# Proposed Concorde Residential Development, Naas Road, Walkinstown, Dublin 12

**Stage 1/2 Quality Audit**

- 1.1 Title** **QUALITY AUDIT CONCORDE S1/2**
- 1.2 Audit Reference Number** **QUALITY AUDIT CONCORDE S1/2 KS 292**
- 1.3 Project Code** **CONCORDEQA**
- 1.4 Date Audit Completed** **11<sup>th</sup> January 2019**
- 1.5 Audit Team**
- Team Leader** **Ken Swaby, ILTP**
- Team Member** **Mark Andrews, ILTP**
- 1.6 Information Received**

68 Pearse Street Dublin 2 tel: 01 6775670  
email: mail@scada.ie fax: 01 6775669  
Client: Development 8  
Project: Concorde site  
Title: Master plan - Detail 02  
Dwg No: 18-489-PD-03 Date Issued: 2019-04-29 Scale: 1:200 @ A1  
Drawn: MA Purpose: Planning Checked: SD

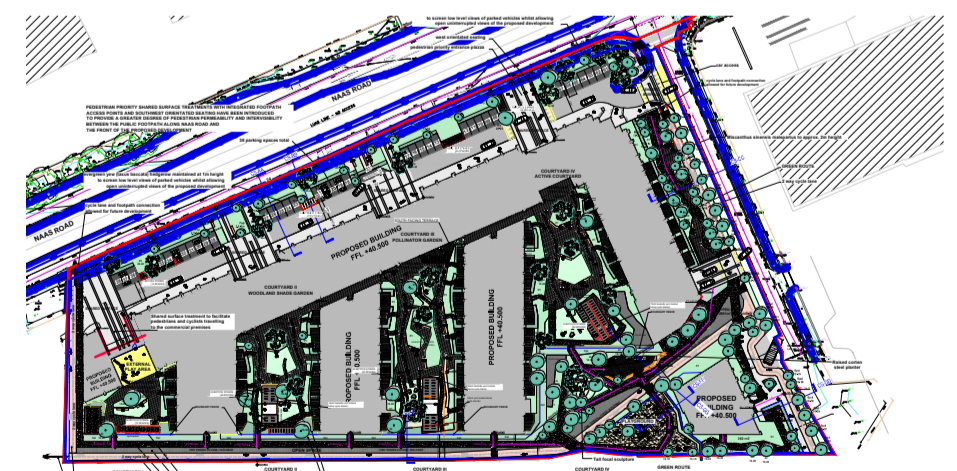
The swept path assessment drawings submitted for audit show a Fire Tender navigating the site via the footpath / cycle track access route along the southern boundary of the site, however the landscape drawing submitted includes planting that appears to conflict with this proposed Fire Tender emergency access route. An inappropriate design layout may result in Fire Tenders being restricted in accessing the required areas in the case of an emergency.

It is recommended that the design team ensures that the drawings for all design disciplines are consistent in layout and detail. It is further recommended that the design team ensures that the facilities provided are appropriate to allow the relevant Fire Tender vehicles required by the local authority to safely manoeuvre within the site.

Para No. in Report	Problem Accepted (Y/N)	Recommendation Accepted (Y/N)	Comments / Alternative Measures (Describe)	Alternative Measures Accepted by Auditor? (Y/N)
4.1.5	Y	Y	This area referred to is a green belt public route and is a planning requirement to comply with the council's development plan. The proposed buildings around this area include windows and balconies that overlook this area creating passive surveillance, consequently addressing potential problems regarding anti-social behaviour.	Y
4.2.1	Y	Y	FURTHER DETAIL ADDED TO BASEMENT LAYOUT DRAWING	Y
4.2.2	Y	Y	FURTHER DETAIL TO BE ADDED TO SEPTH PATH DRAWING AND COORDINATION WITH LANDSCAPE LAYOUT.	Y
4.2.3	Y	Y	As 4.2.2	Y
